KITTITAS COUNTY COMMUNITY DEVELOPMENT SERVICES

Subject: Sinclair Short Plat Final (SPF-18-00001) – Staff Review and Request for Additional Information

Kittitas County Community Development Services (CDS) received your Sinclair (SPF-18-00001) Final Short Plat submittal on June 15, 2018. Final Short Plats must be processed and approved within 30 days of the submittal date. Kittitas County staff has completed the review of your final short plat submittal. As provided below, staff has the following comments, requirements, and/or revisions for your application that need to be addressed prior to final approval and signature of the final short plat mylars.

**SINCLAIR SHORT PLAT**  
**PART OF SECTION 21, T. 18 N., R. 18 E., W.M.**  
**KITTITAS COUNTY, WASHINGTON**

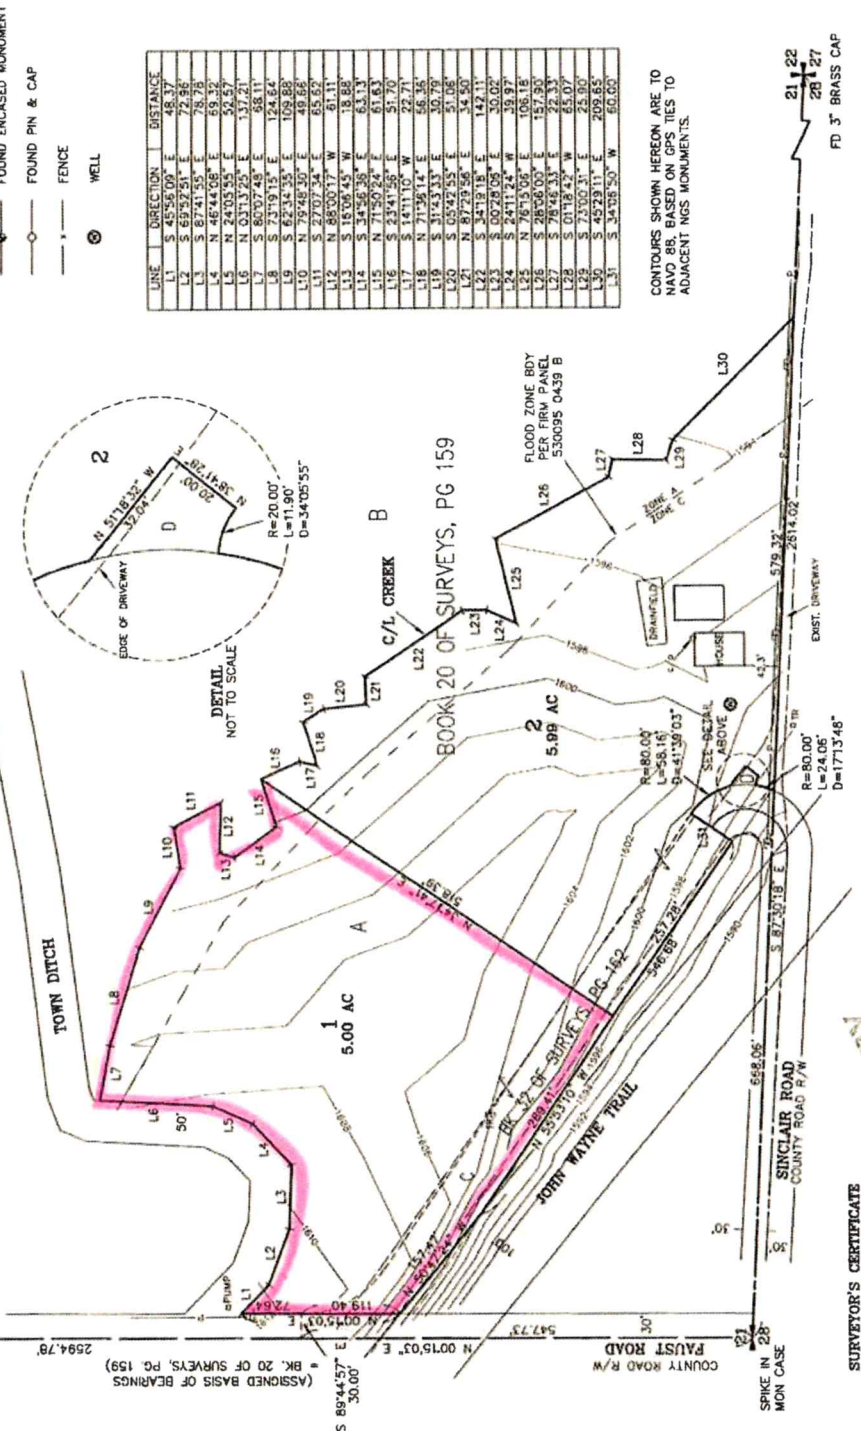
- Reecer Creek should be labeled
- Faust should be labeled as 60' wide
- The South Quarter Corner of Sec 21, is in disagreement with LCR 536433, and a recent survey (ROS 40-192) which call out a pipe and brass cap. Please double check, and if you are in agreement with LCR 536433, please include it as a reference.
